# Memorandum

Date: November 1, 2018

Subject: Falcon Landing Drainage Letter

PPR-18-053

WOODMEN HILLS PHASE III: HEC-1 BASINS

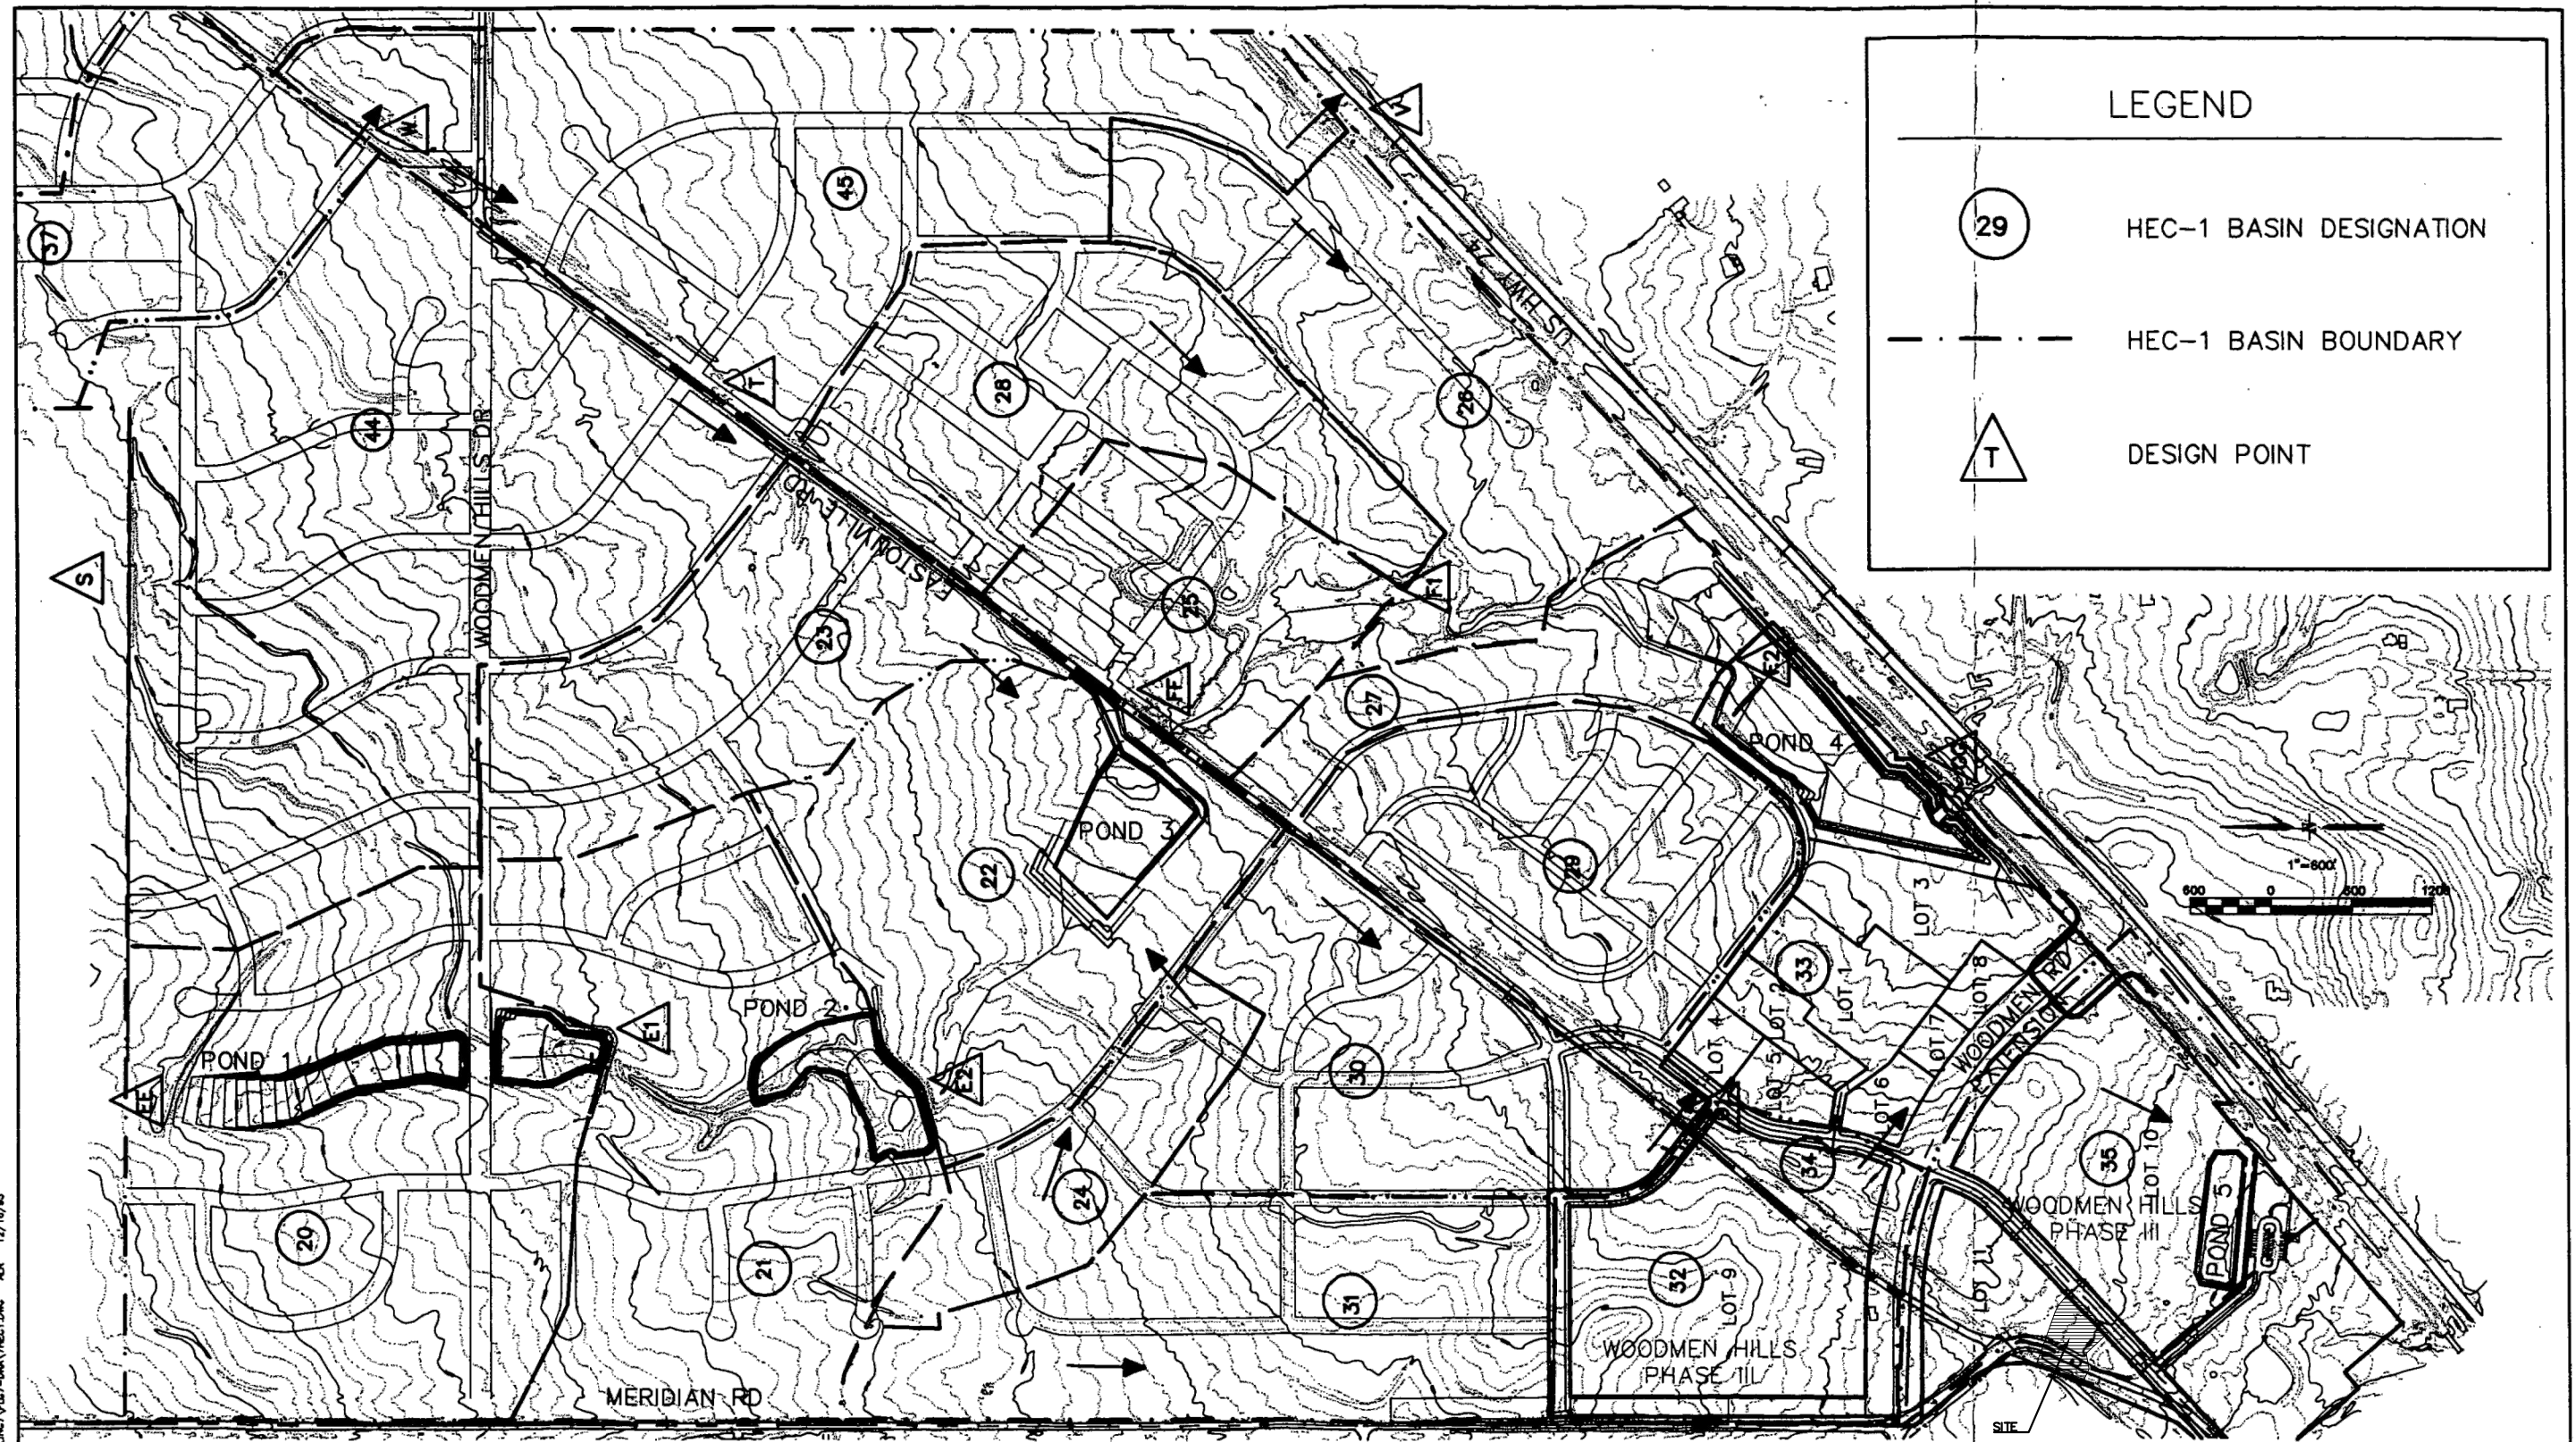
Steve K or Jeff-What is this? We need a drainage plan- don't we?. Where is the water going to. And is the pond they think the water is going to built for all the development or is it undersized?

Please provide a drainage letter that is in conformance with the criteria DCM Vol 1 section 4.5" Small drainage report format".  
Add a section to address the "4 step process".  
DCM Vol 2 section 4.1 & El Paso County ECM I.7.2.  
Provide a drainage map page in the report that shows the site drainage and the outfall.  
Provide the construction drawing for the PLD for this site. (we noted this exists in PPR-08-022, construction drawings)  
Provide a discussion in the report that this PLD is constructed per the requirements and was inspected, and has the capacity for WQCV for this site.  
Provide updated UDFCD drainage calculations for the PLD.
